A Review of the Sainty and Associates (2006) report
'Environmental Constraint Analysis Lot 21 DP 714858,
45 Hearnnes Lake Road Woolgoolga'.

Report prepared for:
BBK Development Corporation Pty Ltd
(ELA Project No. 139-001)

March 2007

RESIDENTIAL SUBDIVISION  
LOT 21, DP714858 HEARNES LAKE ROAD, WOOLGOOLGA  
PLANNING NSW - CONSTRAINTS PLAN

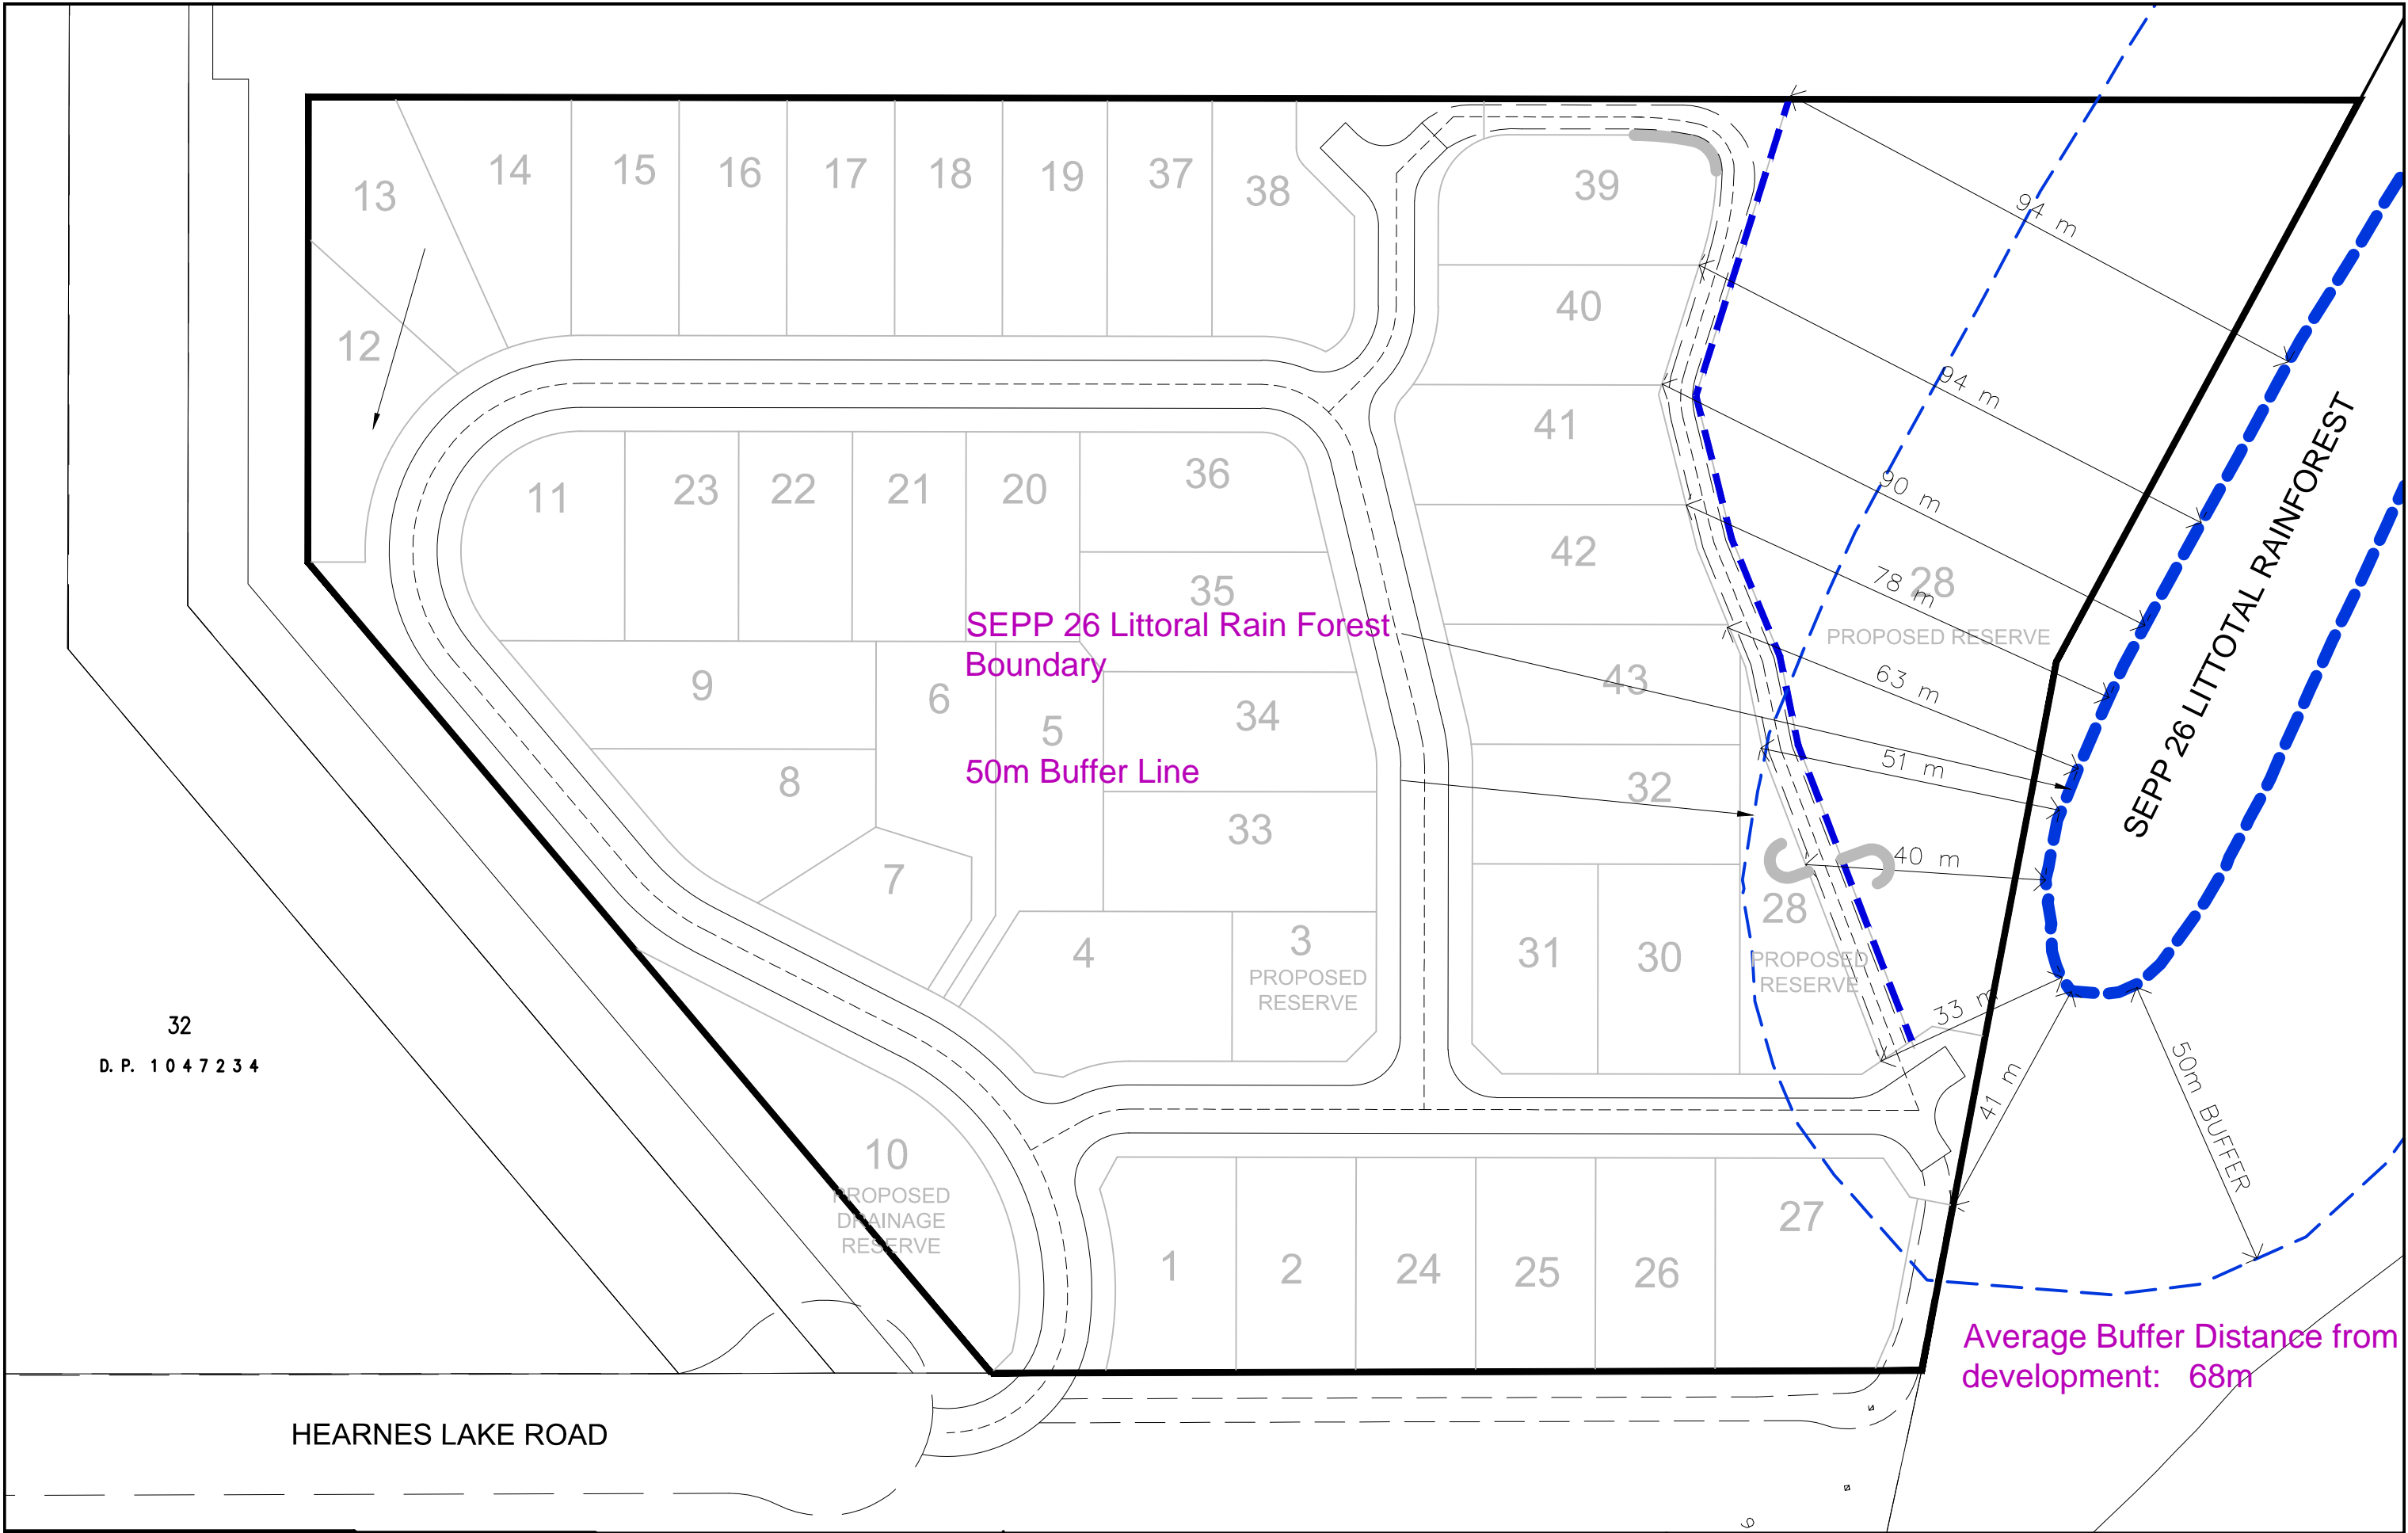
Recommendations arising from the Sainty report are provided on an *Environmental Constraints and Development Potential Map* (the Map) attached to the report. There are some technical problems with some of the boundaries displayed on the Map, as described below.

1. The southern property boundary on the Map is incorrectly shown. The actual property boundary lies approximately 20m south of the location shown on the Map, and more or less follows the northern edge of the unsealed section of Hearnese Lake Road. It appears that the Sainty report relied upon a non-survey version of the CHCC cadastral boundary mapping, which is known to be inaccurate and not suitable for survey-level mapping purposes.
2. The boundary of the 50m buffer to the 3.5m AHD contour of Hearnese Lake is depicted on the Map as a straight line within the southern and south-western boundaries of the subject site. This line would obviously not be a straight line, as it follows a natural contour. Again, this possibly represents a GIS error in mapping.

- The Sainty report has relied on, and perpetuated, inaccurate mapping of the site – the correct southern property boundary lies some 20m south of where it is shown on the Sainty map. The proposed 50m AHD buffer on Hearn's Lake is shown as a straight line in part, which cannot be correct as the buffer follows a natural contour.

ELA recommends that the mapping errors in the Sainty report be corrected, and that additional information produced from site surveys be incorporated into the report.
